**Subject:** BN/43/16 - Angels Nursery, Proposed Residential Development - UPDATED HIGHWAYS REPORT IN LIGHT OF ADDITIONAL INFORMATION RECEIVED SEPT. 2016 DATED 22ND SEPTEMBER 2016

**SUBJECT: BN/43/16/PL - 95 No. dwellings together with access, landscaping open space & associated works.**

**LOCATION: Angels Nursery, Yapton Road, Barnham, West Sussex, PO22 0AY.**

**UPDATED REPORT IN LIGHT OF ADDITIONAL INFORMATION AND DRAWINGS RECEIVED  
20/09/2016 (EMAIL DAVID INNES TO TIM TOWNSEND).**

GENERAL ARRANGEMENT

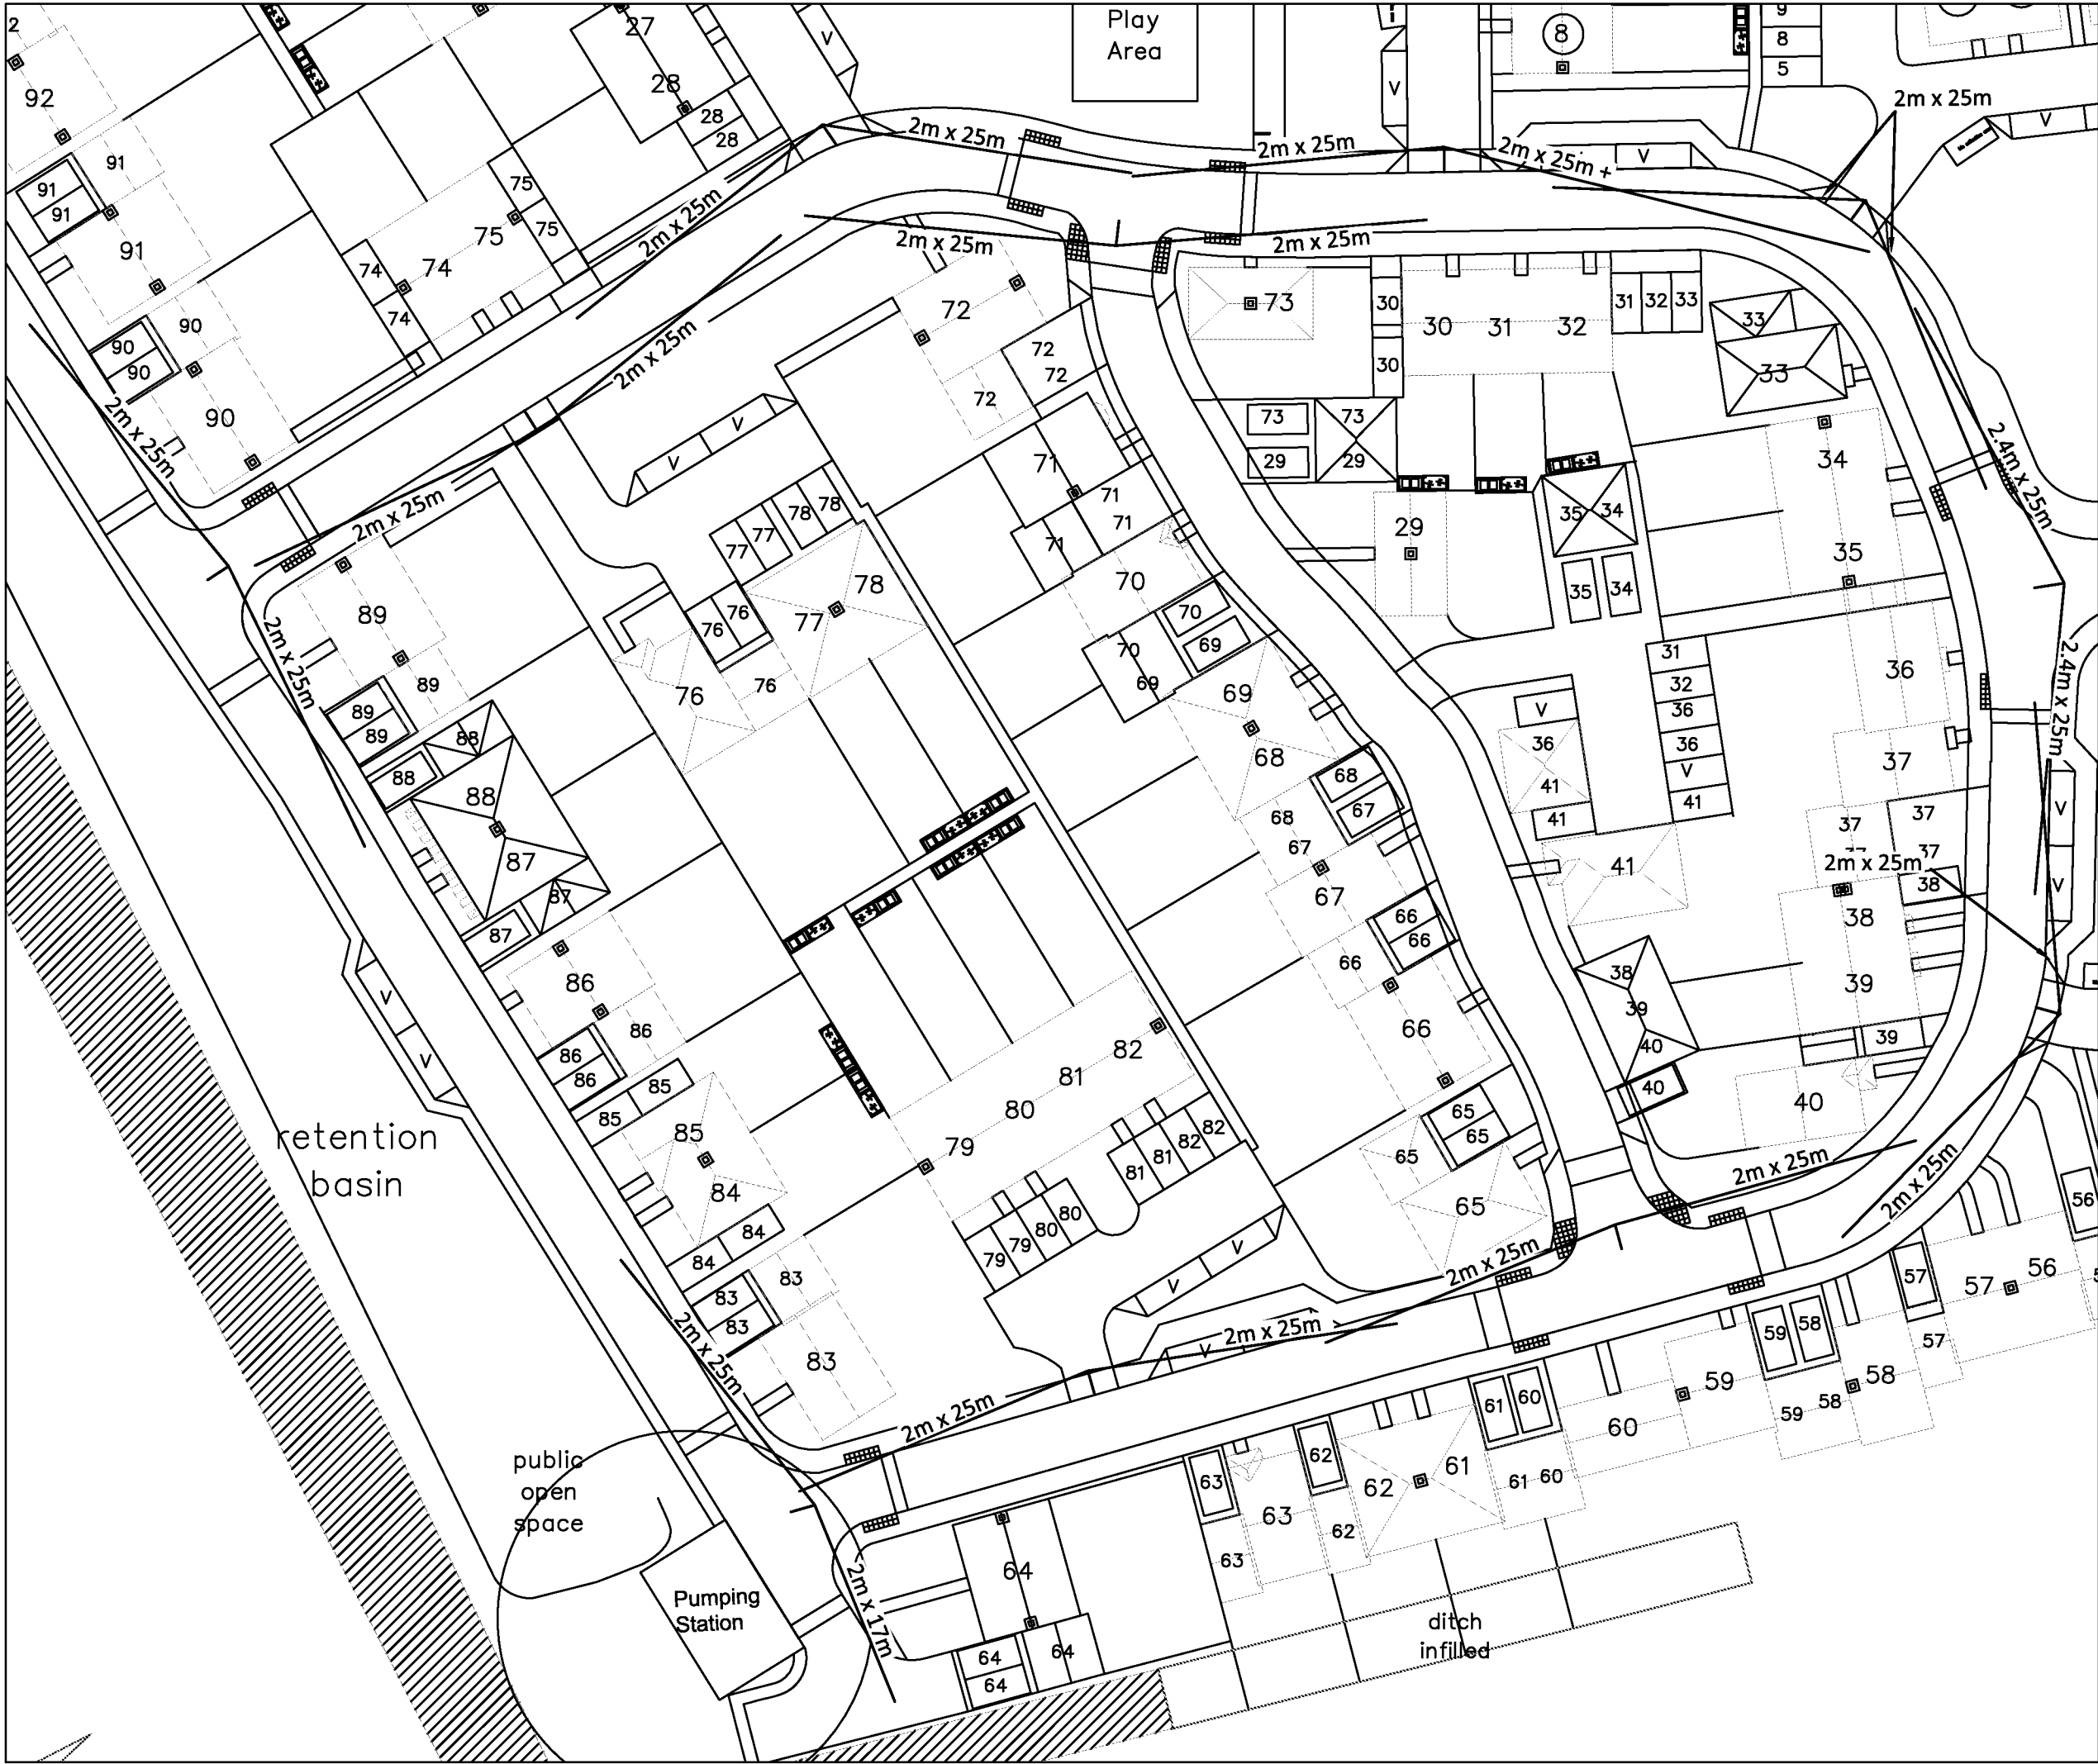
Vehicular access is provided via a single junction with corresponding right hand turning lane and pedestrian refuge on Yapton Road. Pedestrian access points are found alongside and to various areas of the site including Yapton Road, Murrell's Community Centre land and Lillies Caravan Park. The layout has been subject to pre-application discussions, culminating in the layout as now presented in drawing 15081/001 produced by Milestone Transport Planning. The site road layout has also been 'tracked' for access by refuse and fire and rescue appliances. Visibility splays commensurate with a 20mph design speed have been shown at main junctions and communal access points. 2.0m x 2.0m pedestrian intervisibility splays should be provided for all private accesses. Tactile paving should also be provided at all necessary crossing points and where cycle paths join/leave parts of the access road. One small modification required is for the

footways either side of the 'central' shared surface road should be extended slightly to join the road clear of the ramp at the raised table adjacent to plots 40 and 65 (These details will need to be checked and agreed at the S38 and S278 stages).

It is understood that the main access roads are to be offered for adoption under Section 38 of the Highways Act 1980. As such, service margins are generally shown throughout. However, careful attention should be paid at the S38 stage to ensuring adequate margins around the turning heads adjacent to plots 64 and 95. Currently, these are not fully shown in these locations.
